From: Contact Centre (CRM) <contact@ribblevalley.gov.uk>
Sent: 18 April 2022 17:17
To: Planning
Subject: Planning Application Comments - 3/2021/0275

Planning Application Reference No.: 3/2021/0275

Address of Development: Land behind The Dog Inn Market Place Longridge PR3 3RR

Site Section through The Dog Inn, Plot 2 and 36 Darwen Close

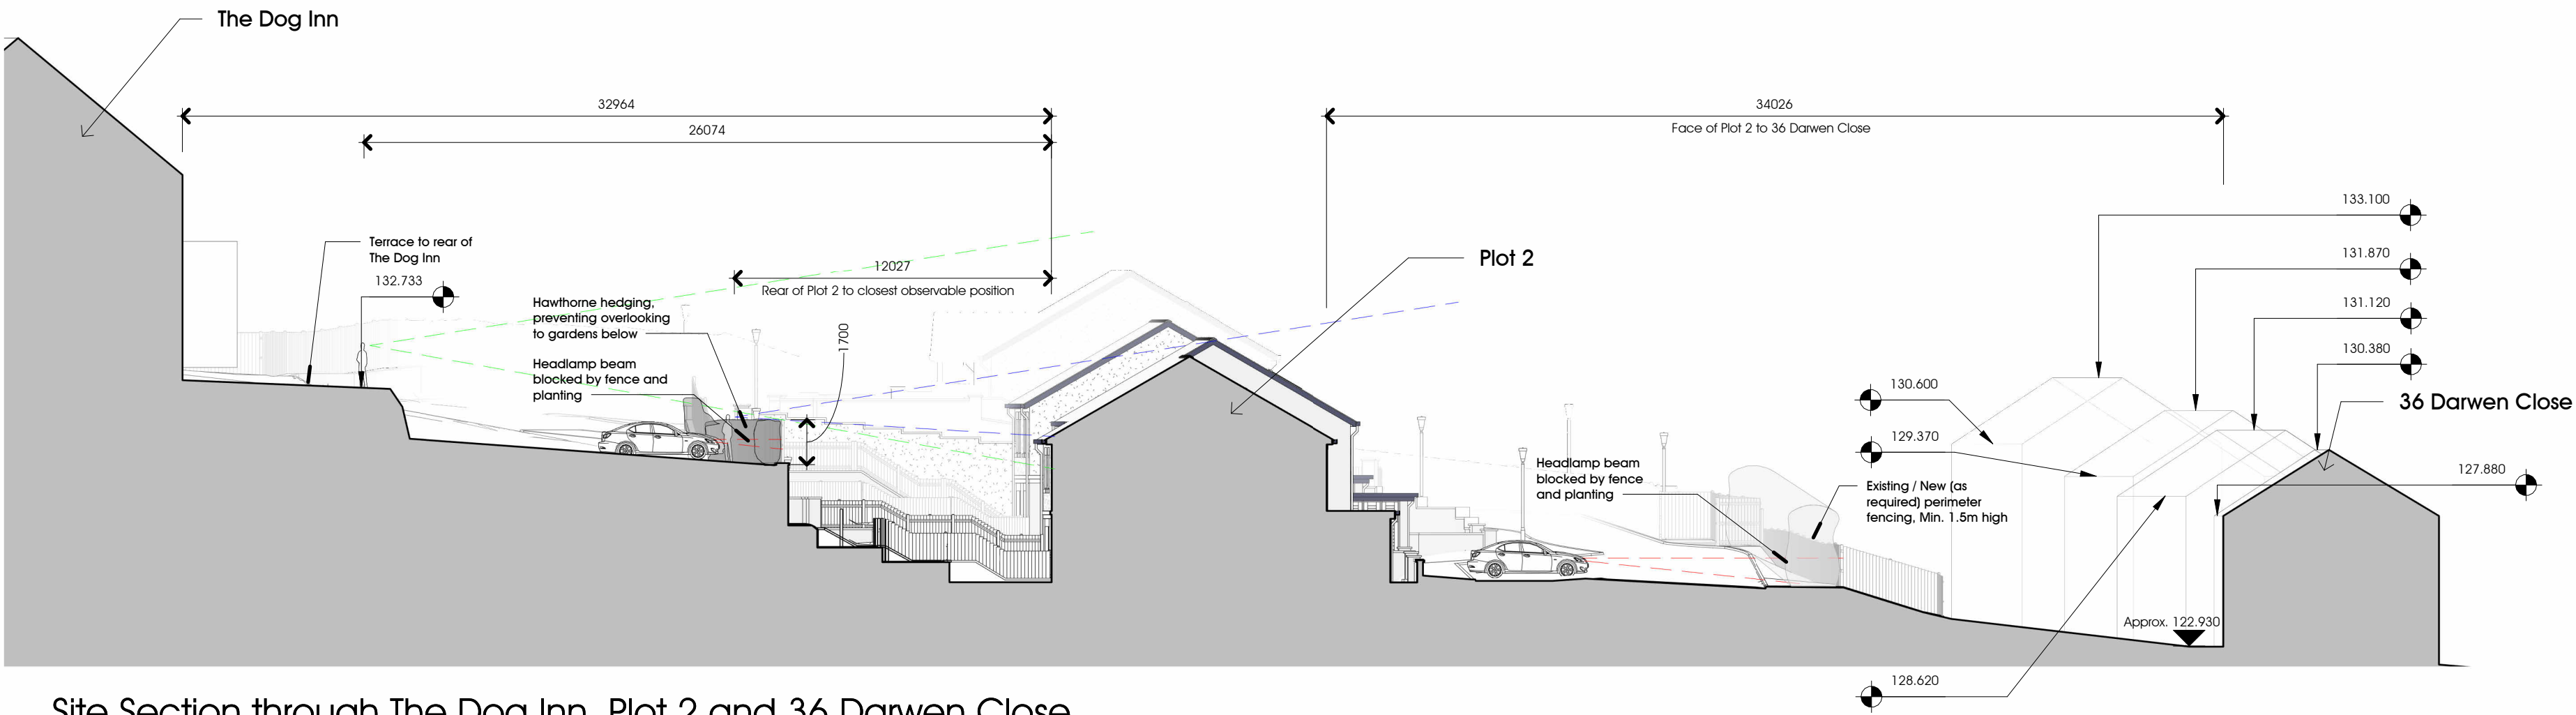
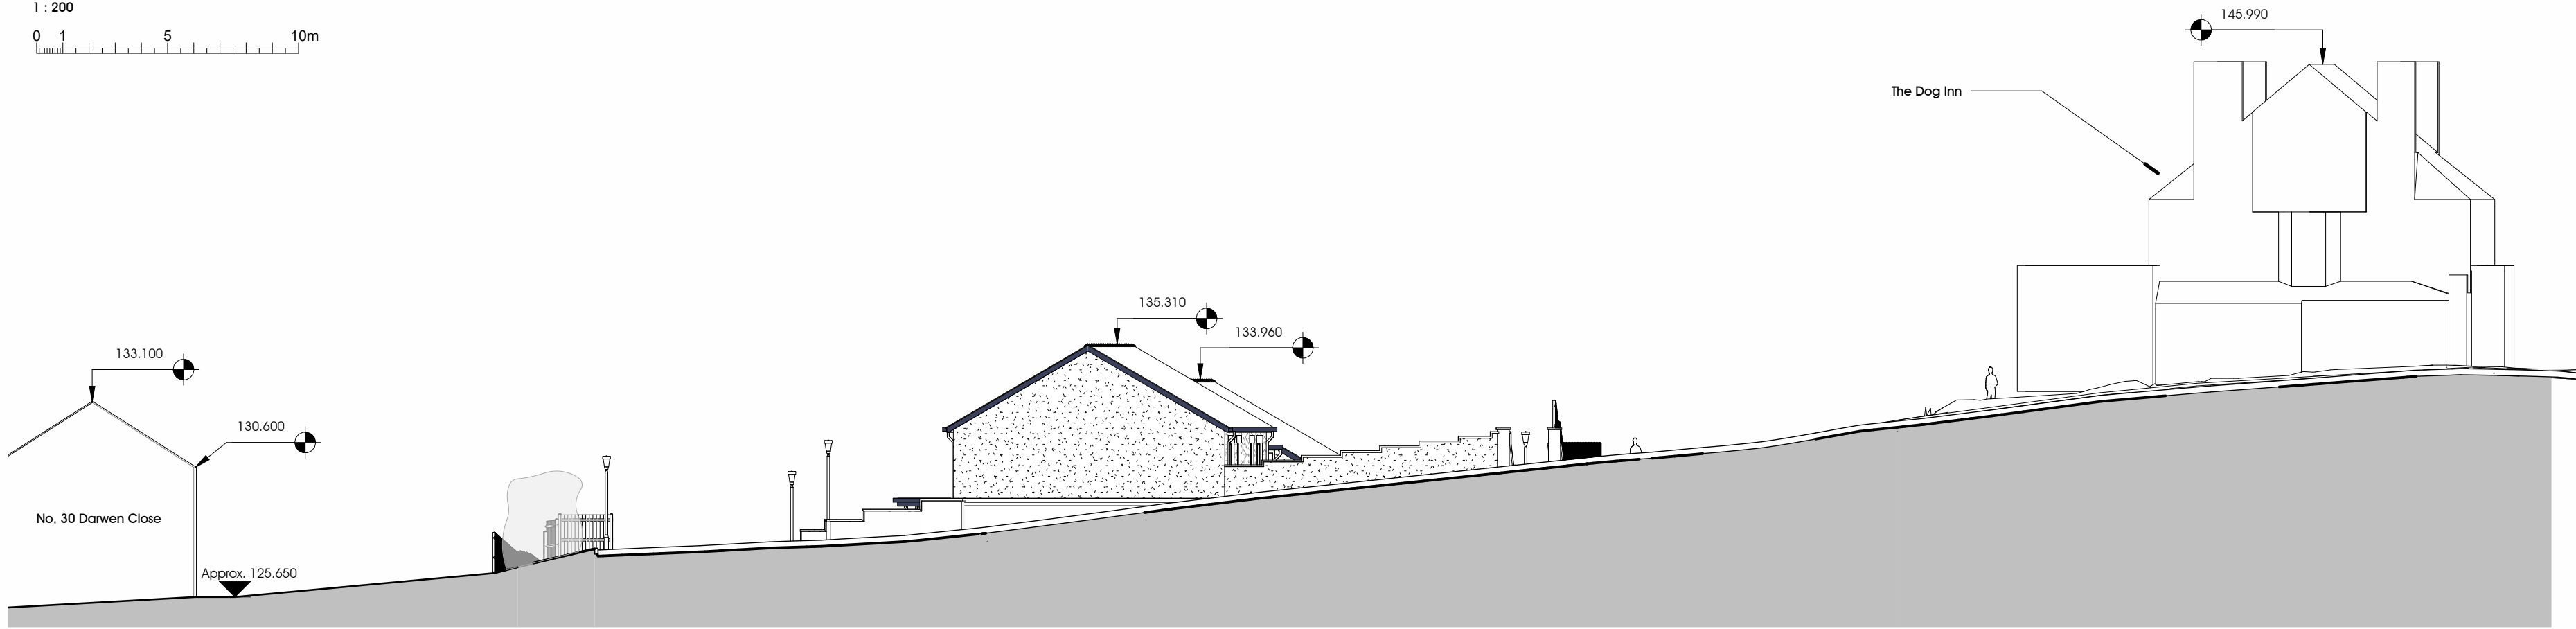
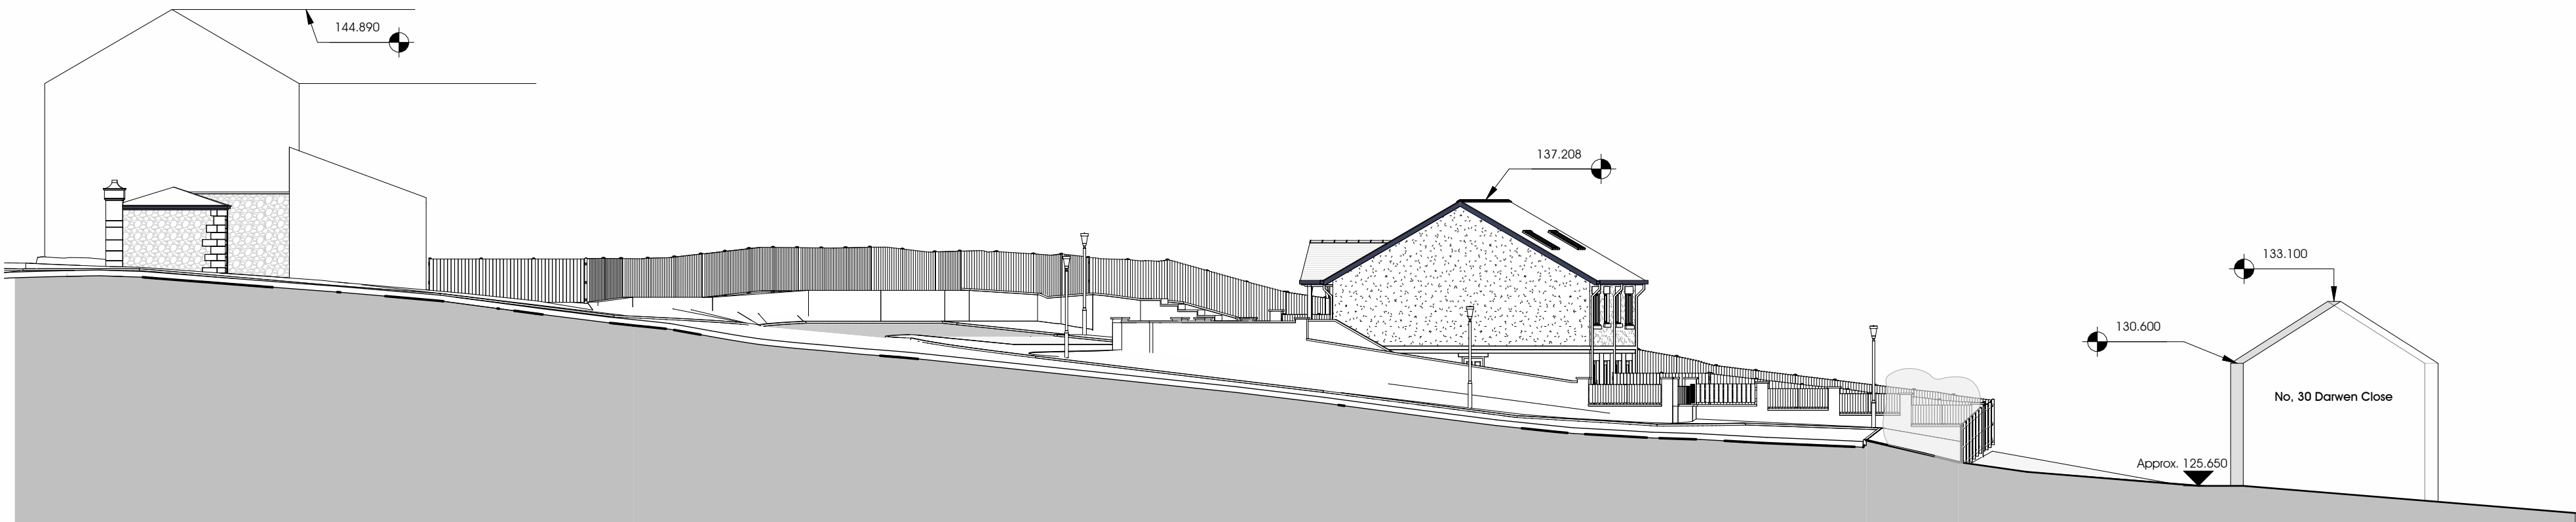
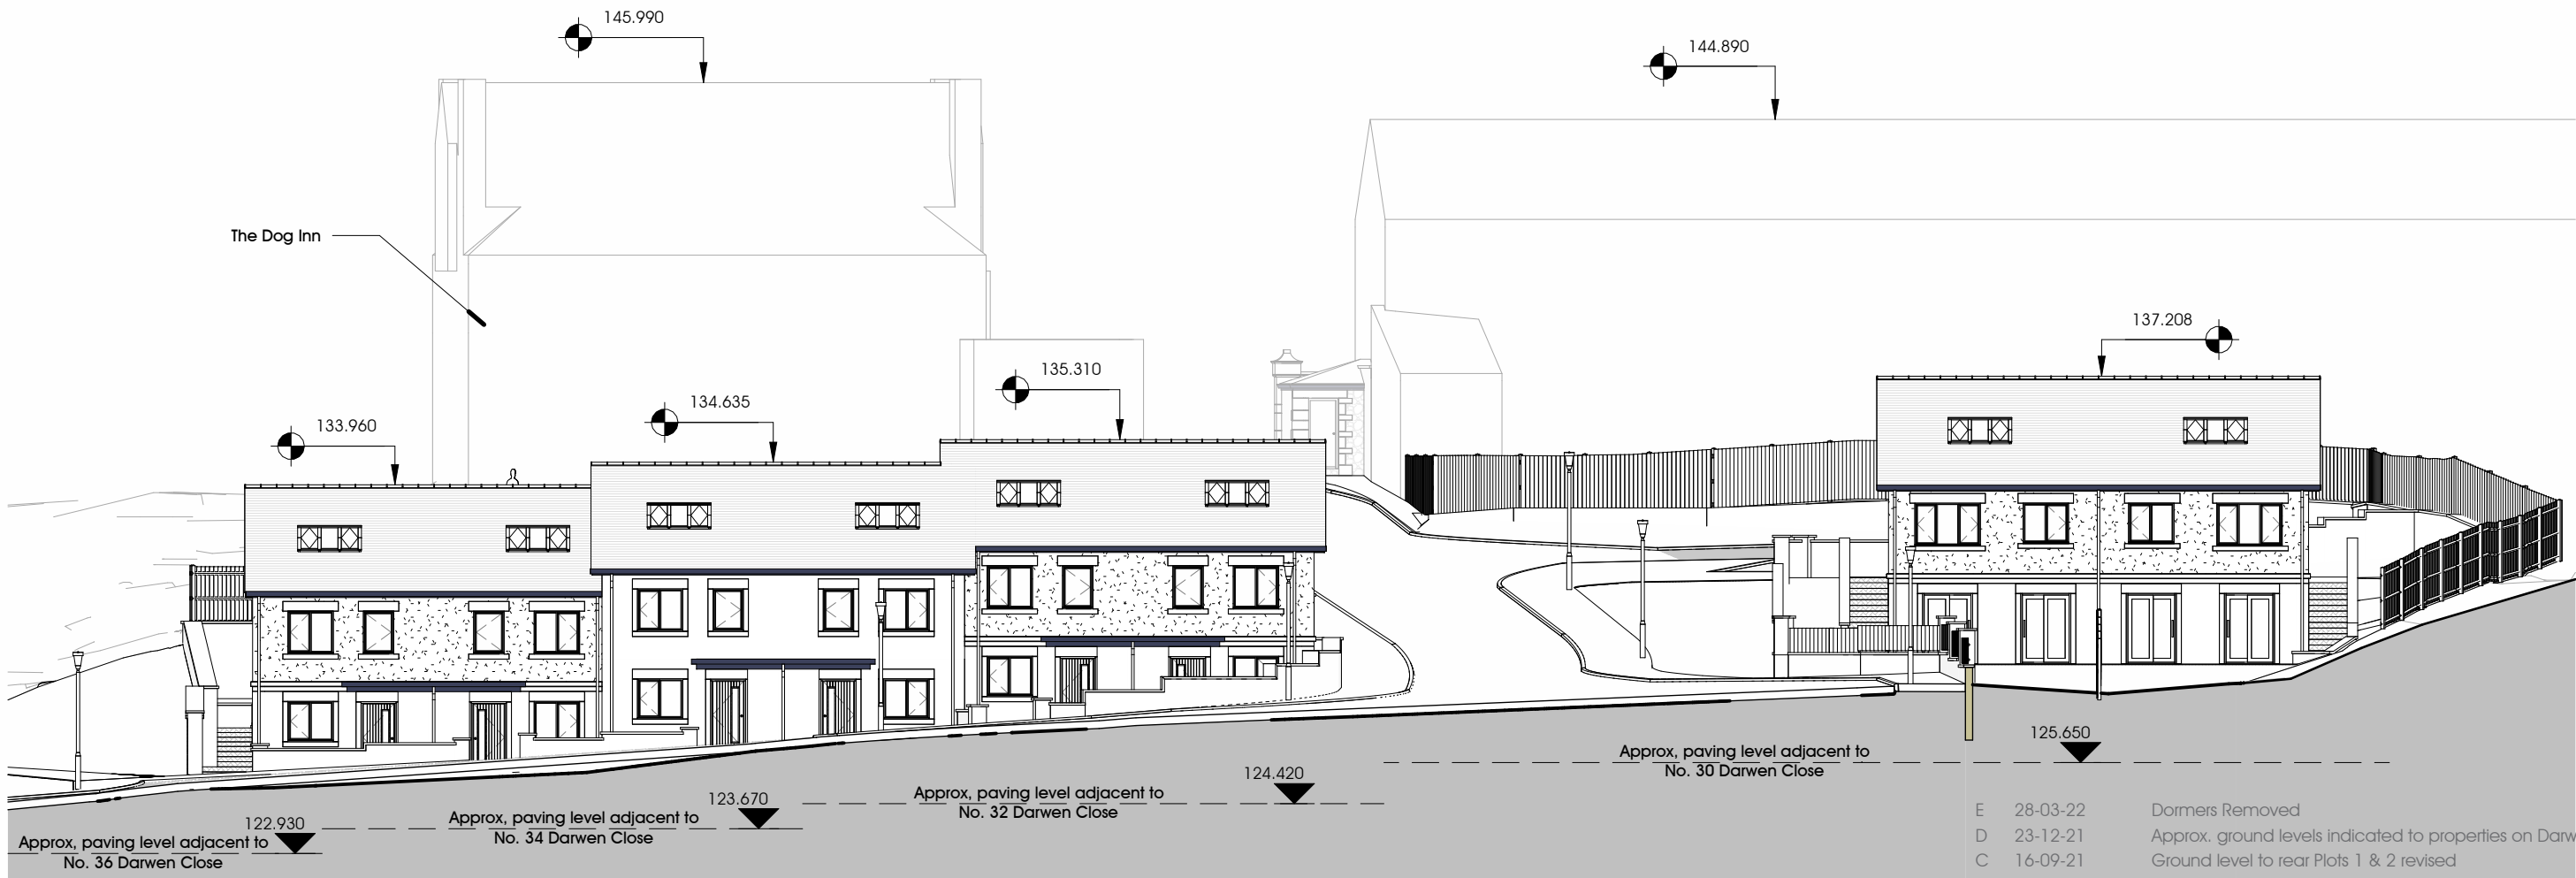
1. Viewing the plans from the properties on Darwen Close, they show that the proposed development will be imposing to the extreme, due to the height difference of the land. We have estimated (not possible to determine the exact distance from the plans) the distance from the boundary hedge to the front elevation to be approximately 15m. This is too close for a building on land [REDACTED]

- a. Please provide the shortest straight line distance from each plot to the properties on Darwen Close that they have a line of sight.
2. Whilst the dormer windows have been removed from the updated proposal we remain concerned that these may be added at a later date.

3. The first floor windows in the proposed plot 5 and 6 are significantly higher than the first floor windows [REDACTED]
[REDACTED] The height differential is approximately 3.2 to 3.7m and is in a direct line of sight, very imposing and [REDACTED]

4. Loss of light – The height of the proposed properties, especially those at the southern end of the west terrace, will have a significant effect on the amount of daylight [REDACTED]

Planning Application  
Proposed Site Plan

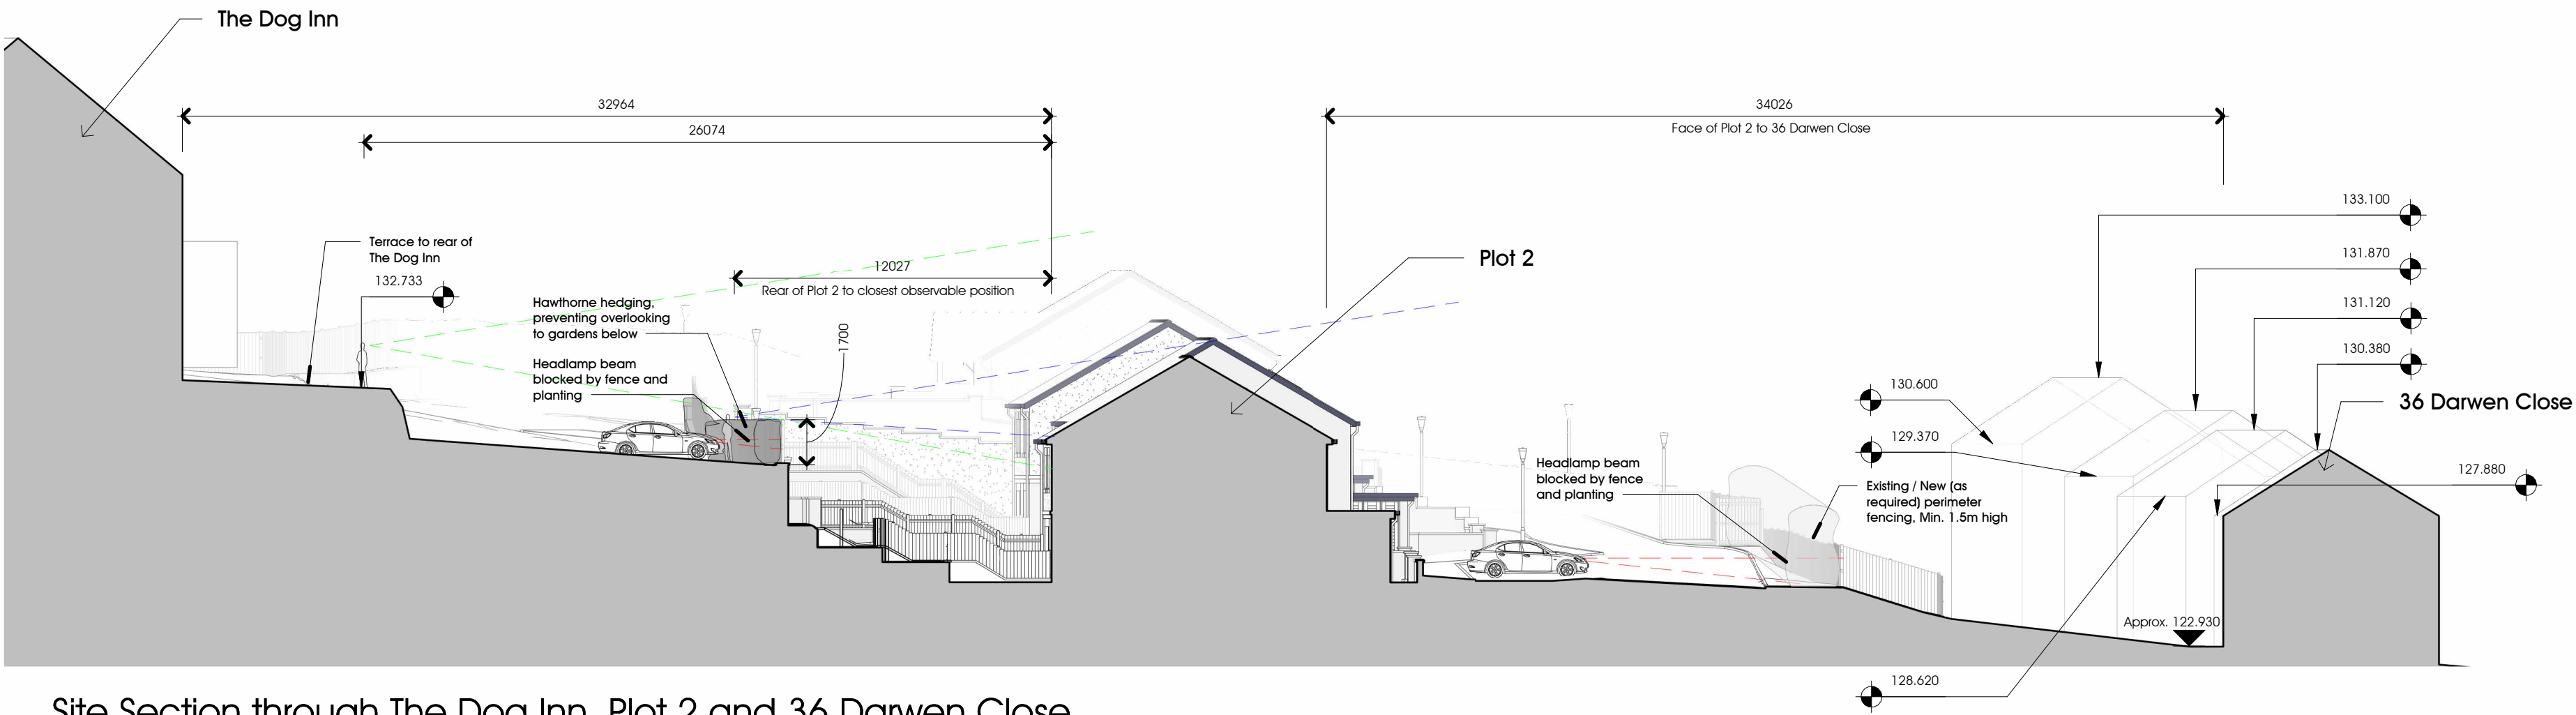
6. Lighting from traffic – The proposed road access and parking for the west terrace means that there will be car headlights shining into both the ground and first floor [REDACTED] With 12 parking spaces, so close, it could well become unbearable especially in the winter months when it is both darker and the beech hedge has less foliage. Whilst we note the proposed fencing, but it is unclear if this will be placed [REDACTED] but if it is then it would have the effect of reducing the natural light [REDACTED]

7. Access road – We are extremely concerned about the access road that has a sharp bend on an incline when it is to be used by heavy vehicles such as the refuse wagon and if required the emergency services. We fear for our safety, especially in icy conditions, if a heavy vehicle loses control [REDACTED]

8. We object to the proposed refuse collection point as this may be used on non bin collection days and may become a public health issue if rubbish is allowed to build up. The bins should be collected from the front of properties which then means the residents are responsible for their own bins.
